Application Ref:	3/2025/0364			 <div>Ribble Valley Borough Council</div> <hr/> <div>www.ribblevalley.gov.uk</div>
Date Inspected:	08/10/2025	Site Notice:	N/A	
Officer:	MC			
DELEGATED ITEM FILE REPORT:				APPROVAL

Development Description:	Retention of a safety fence.
Site Address/Location:	Longridge Cricket Club, Chipping Road, Longridge, PR3 2NB

ELEVATION
(ALONG CHIPPING LANE)
Scale 1:100

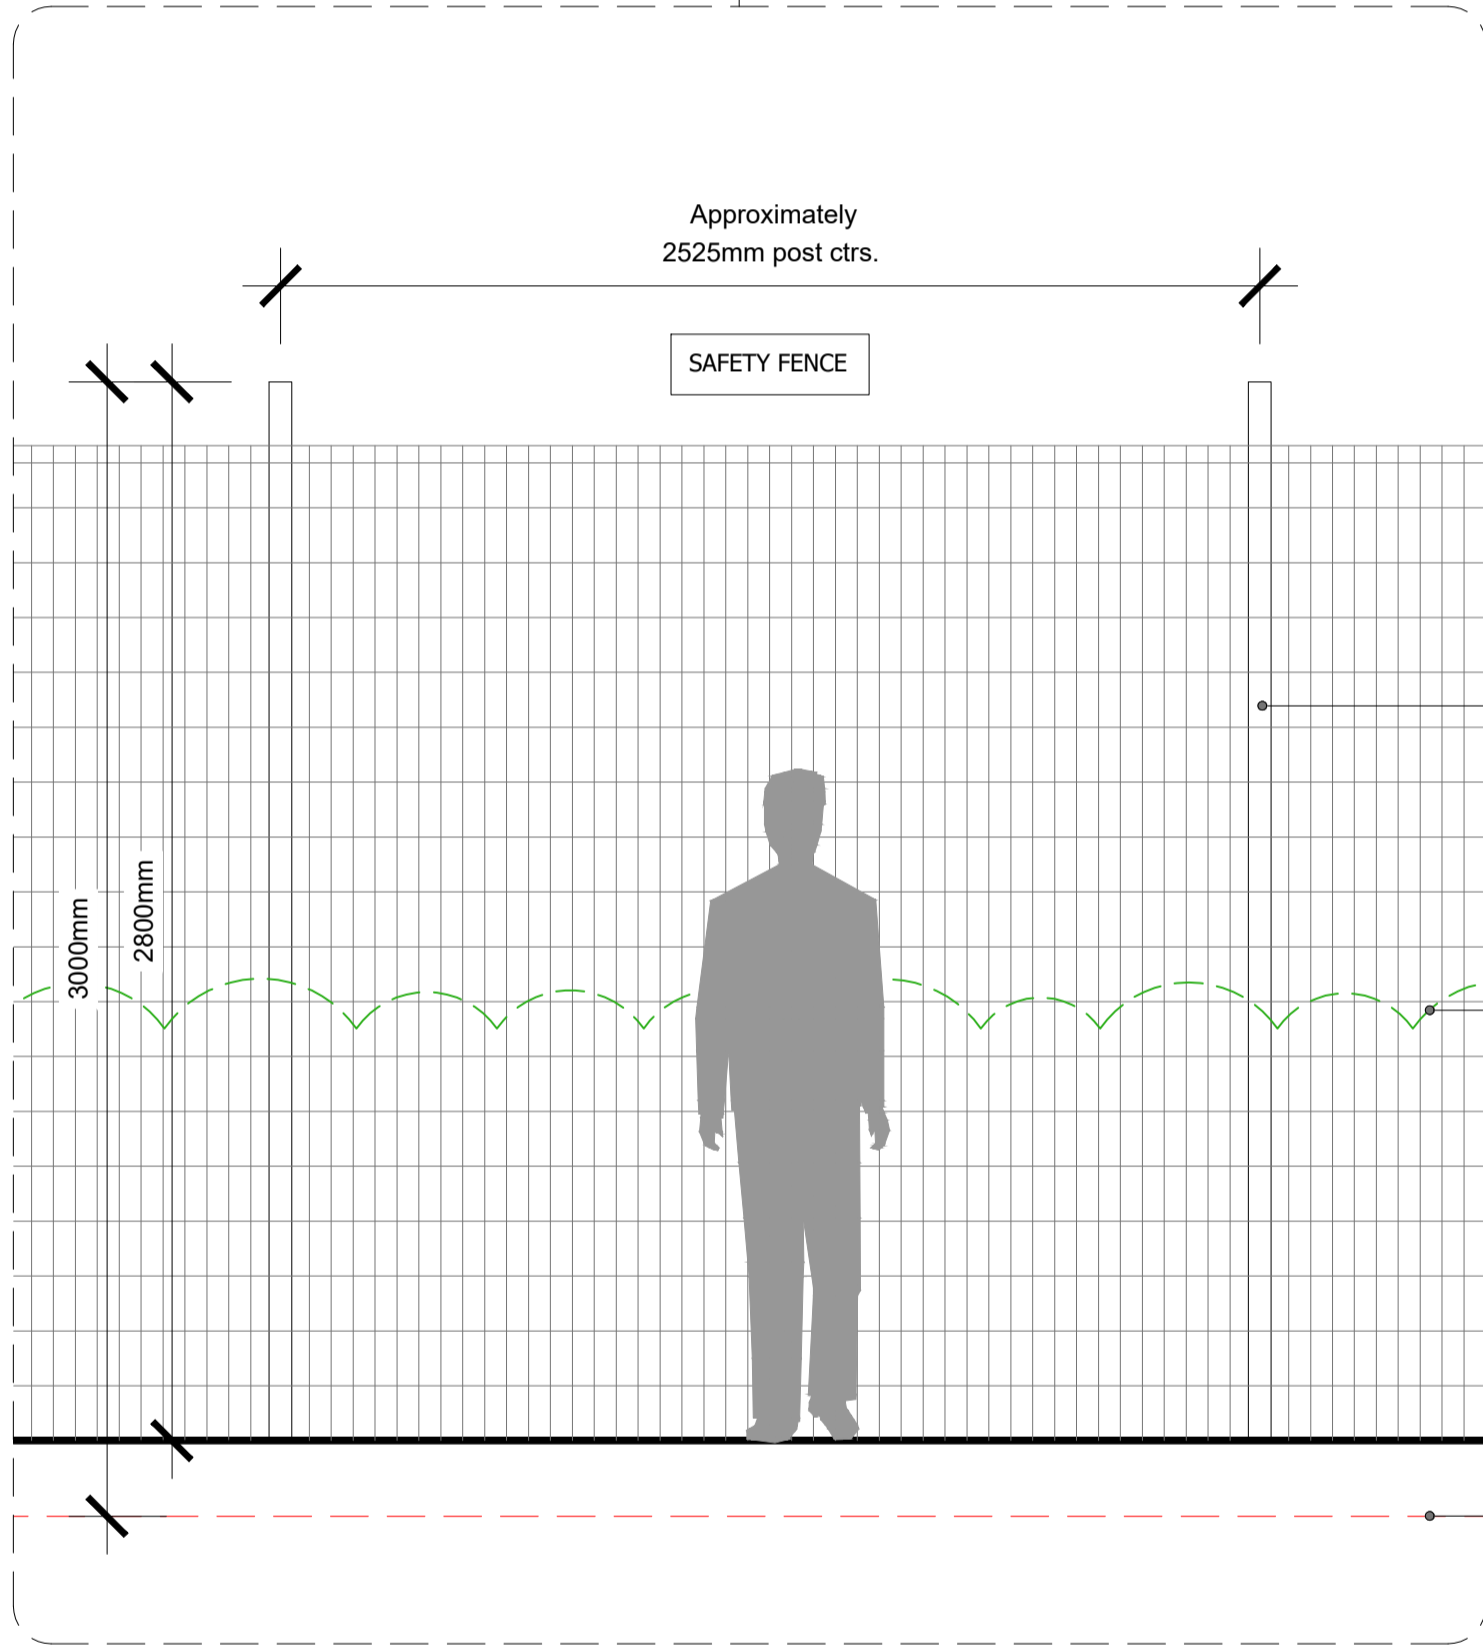
The elevations have been updated to accurately reflect the fence height (2.8m from the roadside and 3m from inside the cricket grounds). In addition, the site plan has also been updated to show the existing hedgerow immediately adjacent to the fence.

Concerns have been previously raised at pre-application stage with regards to the installation of a fence of this height and the impact that it would have on the visual amenities of the surrounding area, including the setting of the Forest of Bowland National Landscape.

A landscaping management and maintenance plan could ensure that the hedge is maintained to an appropriate thickness and height to minimise the visual impact of the development and provide a neutral impact on the setting of the Forest of Bowland National Landscape. A letter has been received from the applicant outlining the suggested management and maintenance of the hedge which shall include retaining the hedge and keeping it maintained at approximately 1.8m which is considered sufficient adjacent to the 2.8m. This document also notes that the hedge would be subject to a formal cut no more than twice per calendar year and further pruning would take place where necessary (limited to light shaping and height control to maintain the minimum 1.8m height, encourage healthy growth and retain a dense habitat. It is considered that this can be secured by way of planning condition.
